Preferred Project Report (Revised) for

Major Project Application No. MP09-0166 for Altitude Aspire, Terranora

Submitted to
Newland Developers Pty Ltd
April 2013

Title:	Revised Preferred Project Report
Author(s):	B. Lees and D. Holstein
Status:	Issue 1 – Revised PPR
Client:	Newland Developers Pty Ltd
Application No:	09_0166
Synopsis:	This Preferred Project Report (PPR) addresses the issues the Department of Planning (DoP) and Tweed Shire Council (TSC) have identified as requiring resolution, confirmation and/or clarification from the original Preferred Project Report (PPR) for a proposed development designated as 'Altitude Aspire' which forms part of the overall proposed development of land identified in TSC's Residential Development Strategy as 'Area E', located at Terranora NSW. The submissions made to the DoP during exhibition of the Environmental Assessment (EA) of the proposed 'Altitude Aspire' development with consideration to TSC Development Control Plan DCP B24, and the engineering criteria listed in A5 of the Tweed DCP have been specifically addressed within the report. The Revised PPR continues to establish the basis on which the development may be serviced with the rel

NEWLAND DEVELOPERS PTY LTD	09-374 09-04-2013
TERRANORA PRECINCT 1 EARTHWORKS SECTIONS LAYOUT	SK 3635 REVISION C

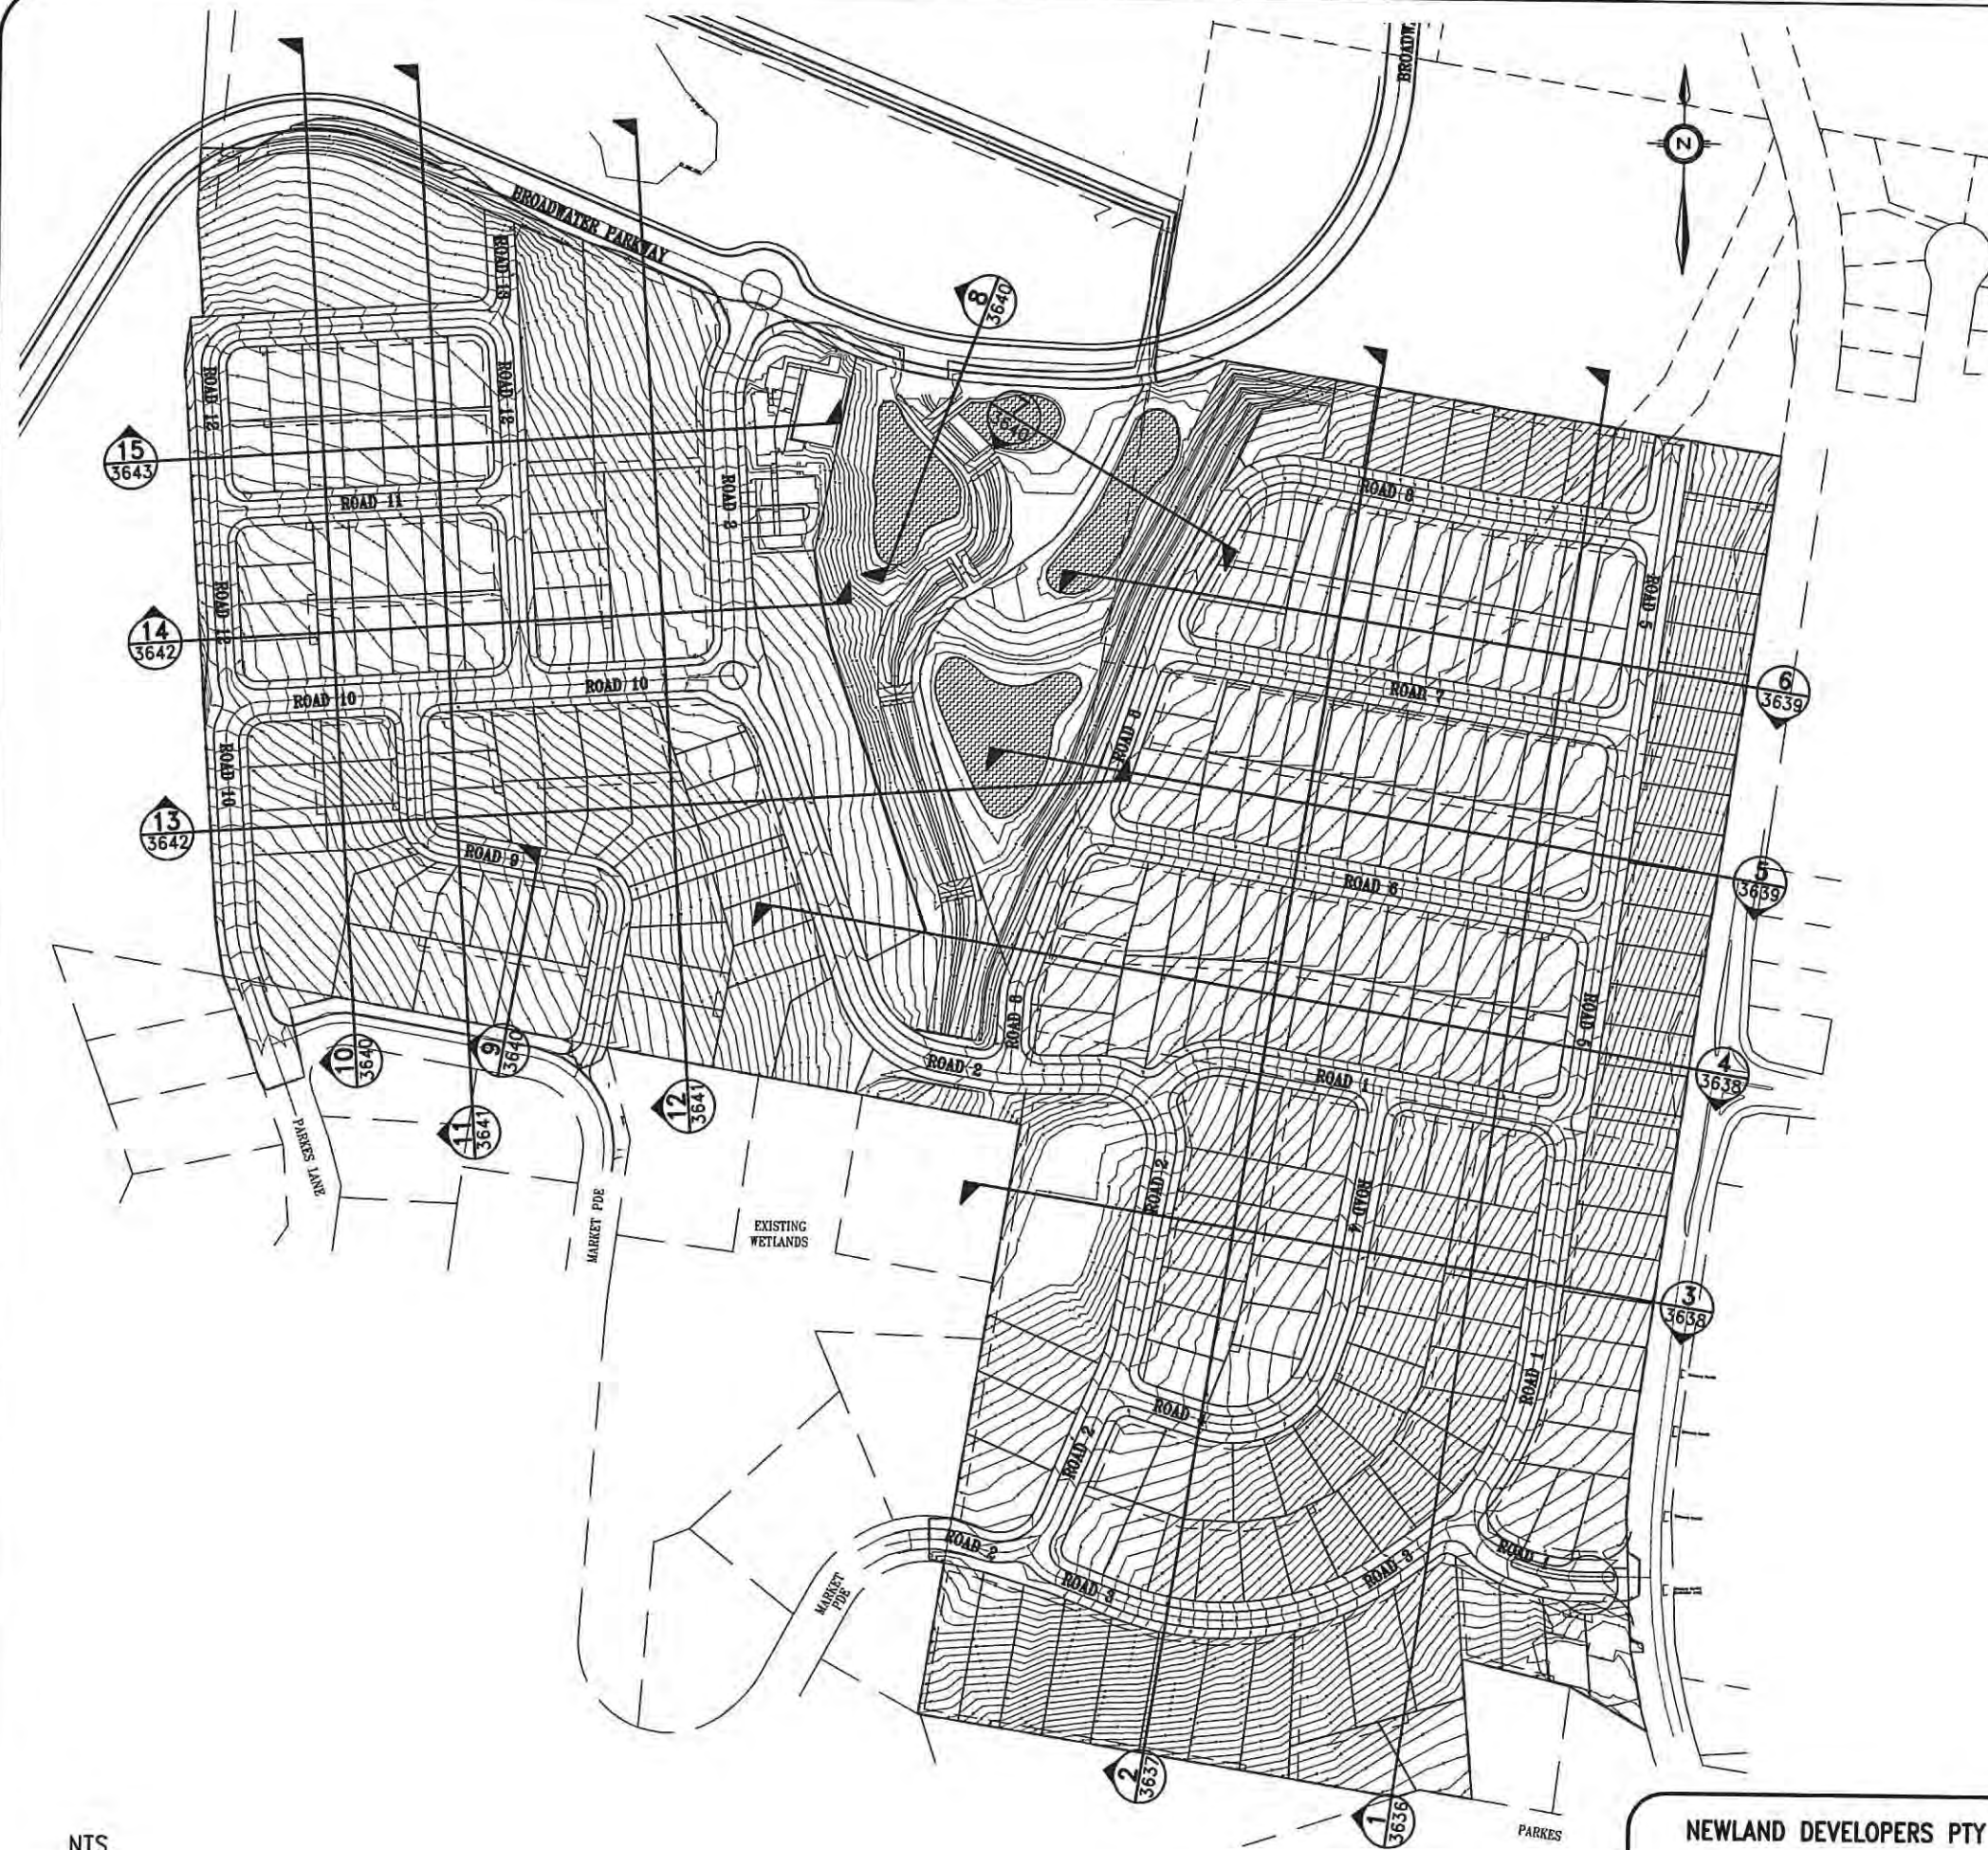
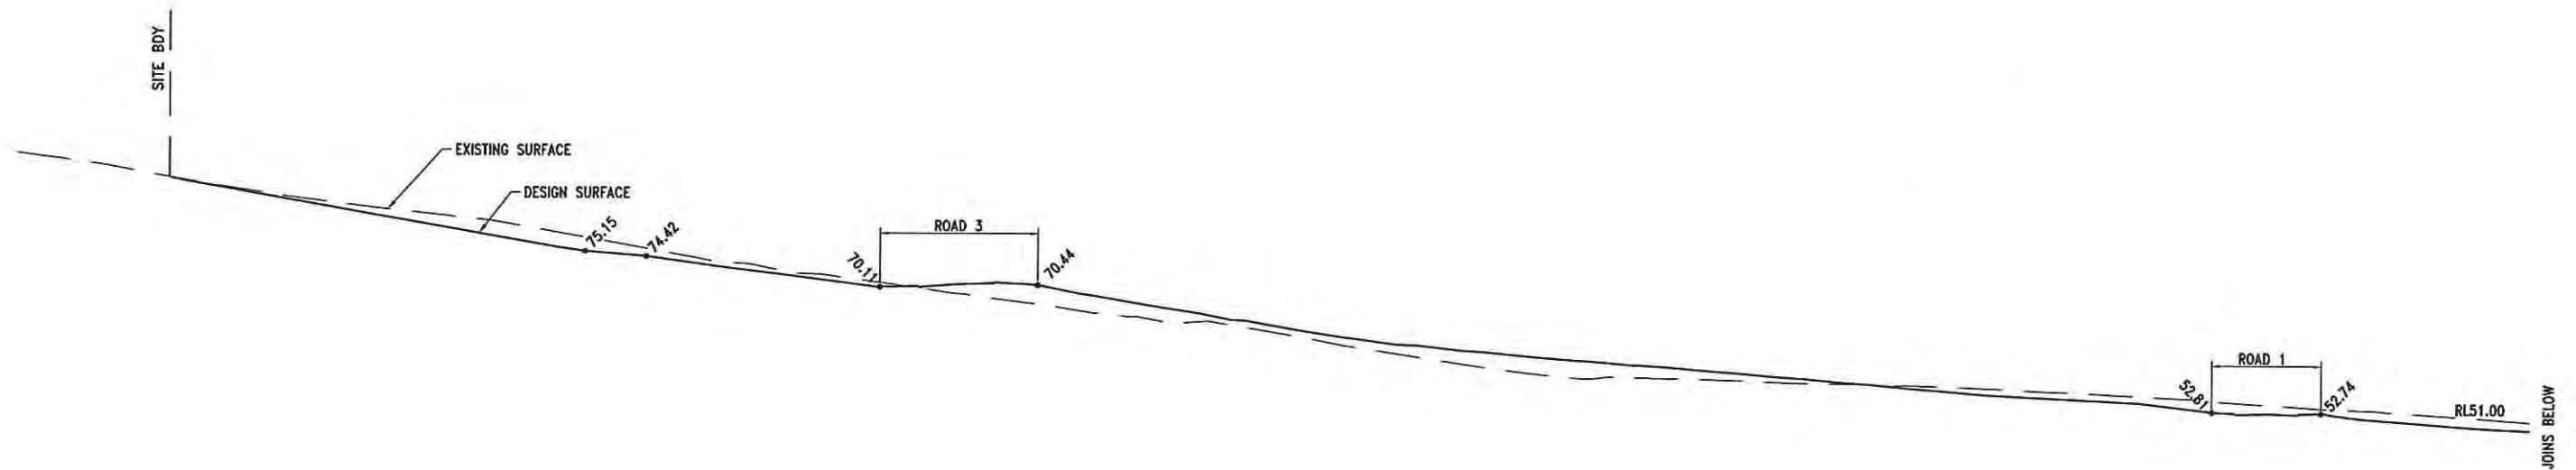
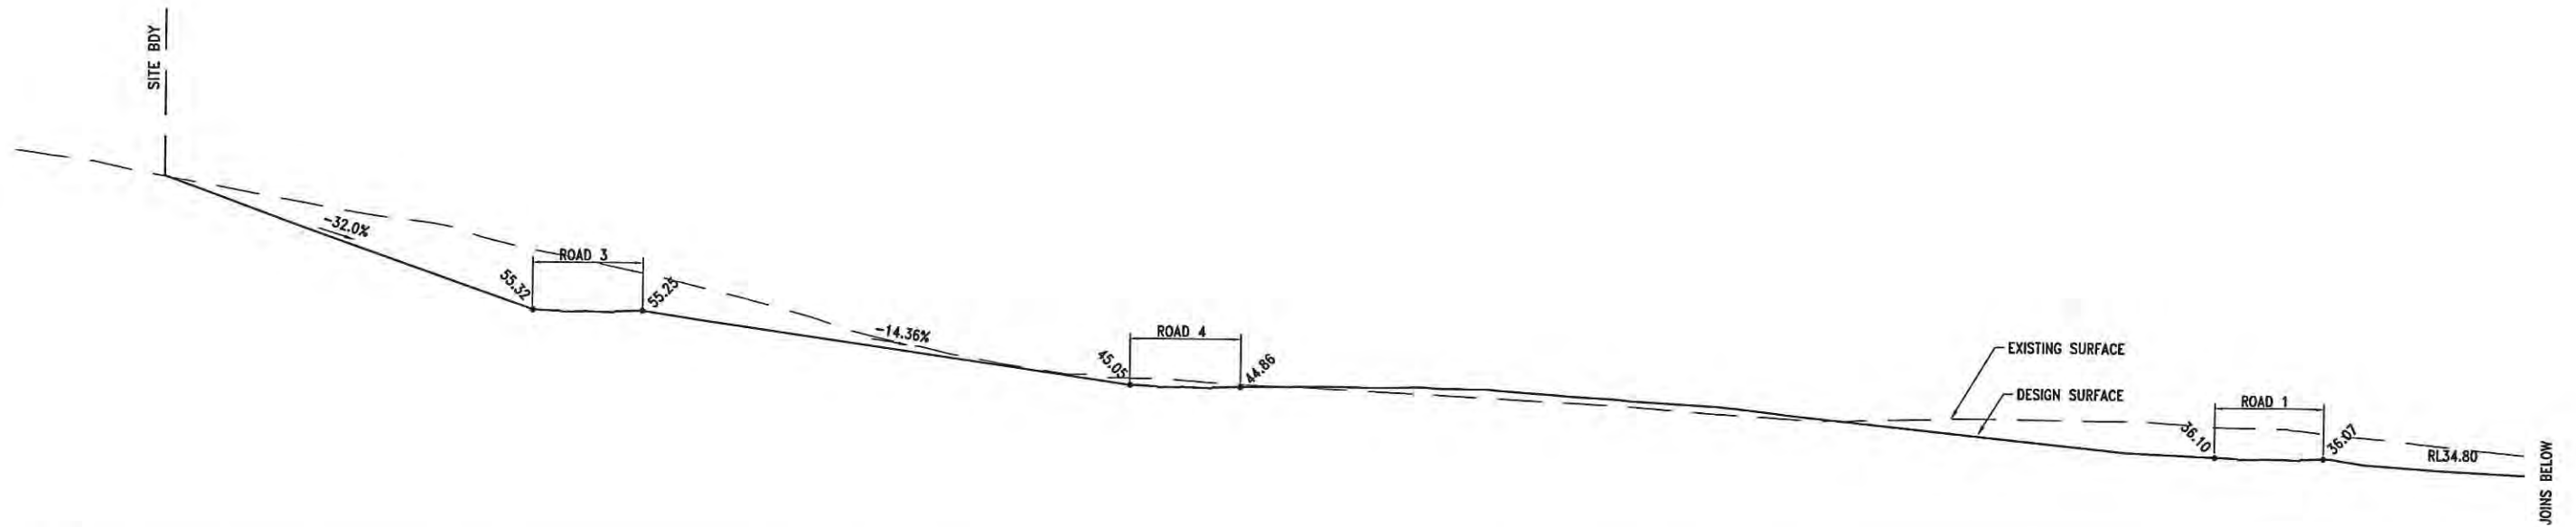
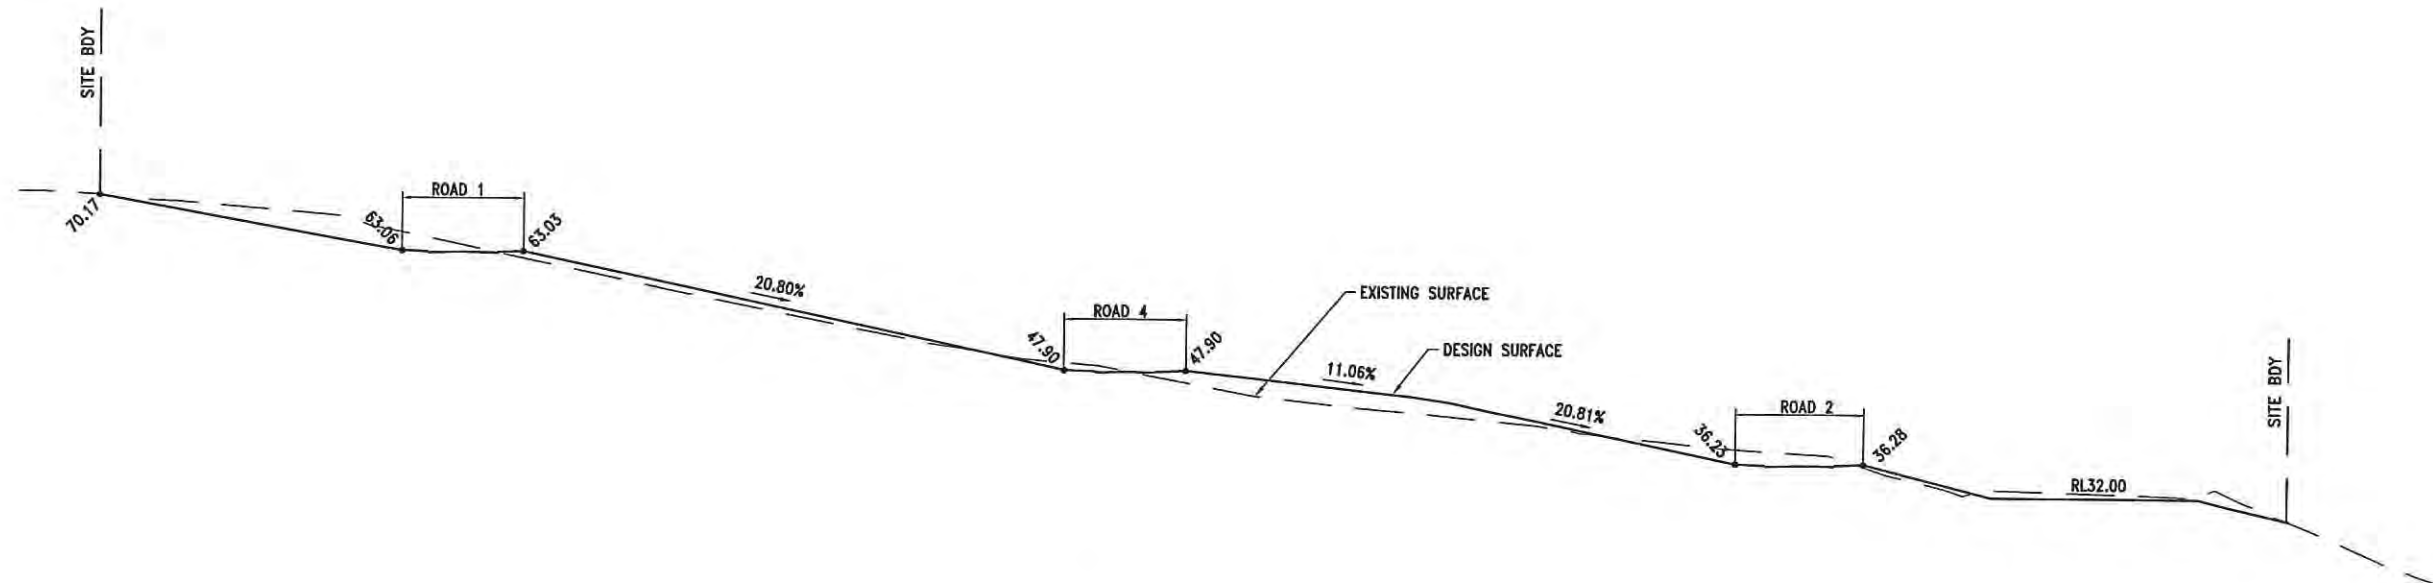
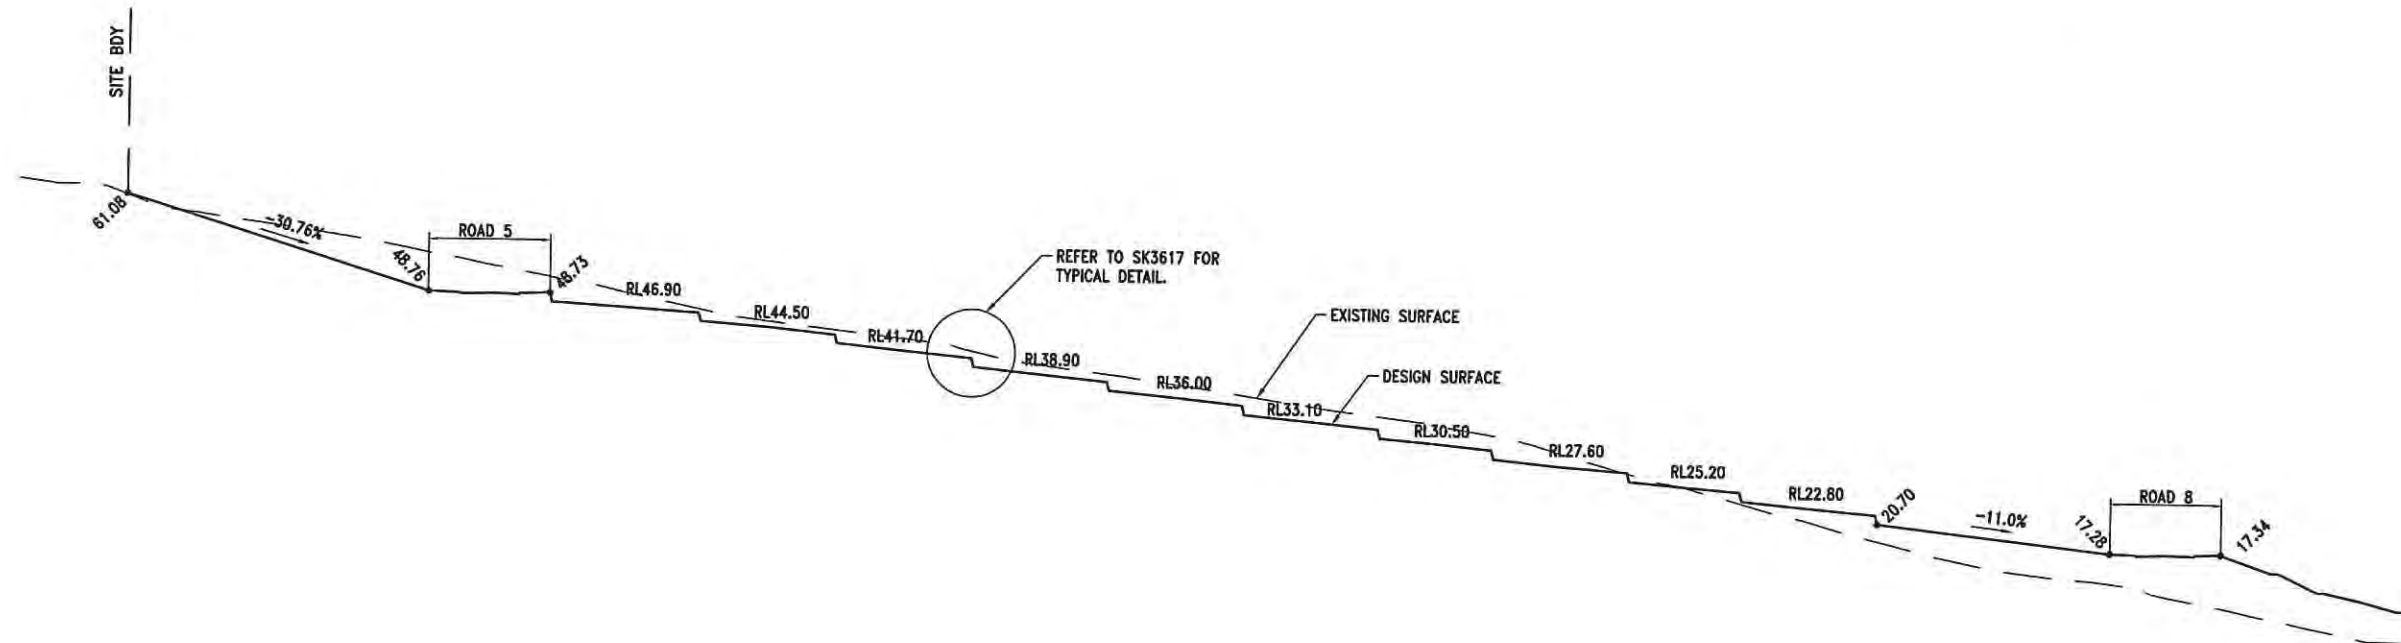
Project Element	Agency	Submission Item	Response	Reference in this report
Landforming	DoP	Investigate the use of stepped built form as opposed to traditional slab on ground. Reduce road constructed perpendicular to the dominant slope.	Development includes a mix of lot types on flat, moderate, steep and extreme slopes.	Section 2.5
		The layout is inconsistent with the DCP in regards to filling which specifies no more than 5m of filling over no more than 10% of the site (or 15% if demonstrated it is required to minimise adverse effects on the environment	Revised layout complies with DCP A5 - D6.05.3	Section 3 – DGR 7.1 & Appendix 5 – Earthworks Phasing Plan
		Produce a DTM of the finished subdivision landform, with particular attention on how the proposed landform relates to neighbouring properties and detailed justification on any departures from current policy.	Impact on neighbouring properties has been minimised.	Section 2.5, Section 4 – A5.4.5 & Appendix 5 – Earthworks Sections Layout and Earthworks Cross Sections

Perimeter retaining walls up to 3m high are proposed along the eastern boundary along Fraser Drive and the south-western boundary adjacent to Market Parade.	Earthworks have been revised removing retaining walls at this location.	Appendix 5 – Earthworks Layout Plan and Earthworks Sections
		2 x 3m high tiered walls are also proposed along the south-eastern boundary adjacent to residential lots off Parkes Lane. This does not comply with D6, which restricts perimeter subdivision walls to a maximum height of 1.2m.	Earthworks have been revised removing retaining walls at this location.	Appendix 5 – Earthworks Layout Plan and Earthworks Sections
		Councils' adopted policy is that subdivisions should be designed to fit the topography rather than altering the topography to fit the subdivision. The report does not provide any specific justification for (above) departures from Council's standards, and as such, variations are not supported	Development includes a mix of lot types on flat, moderate, steep and extreme slopes.	Section 2.5
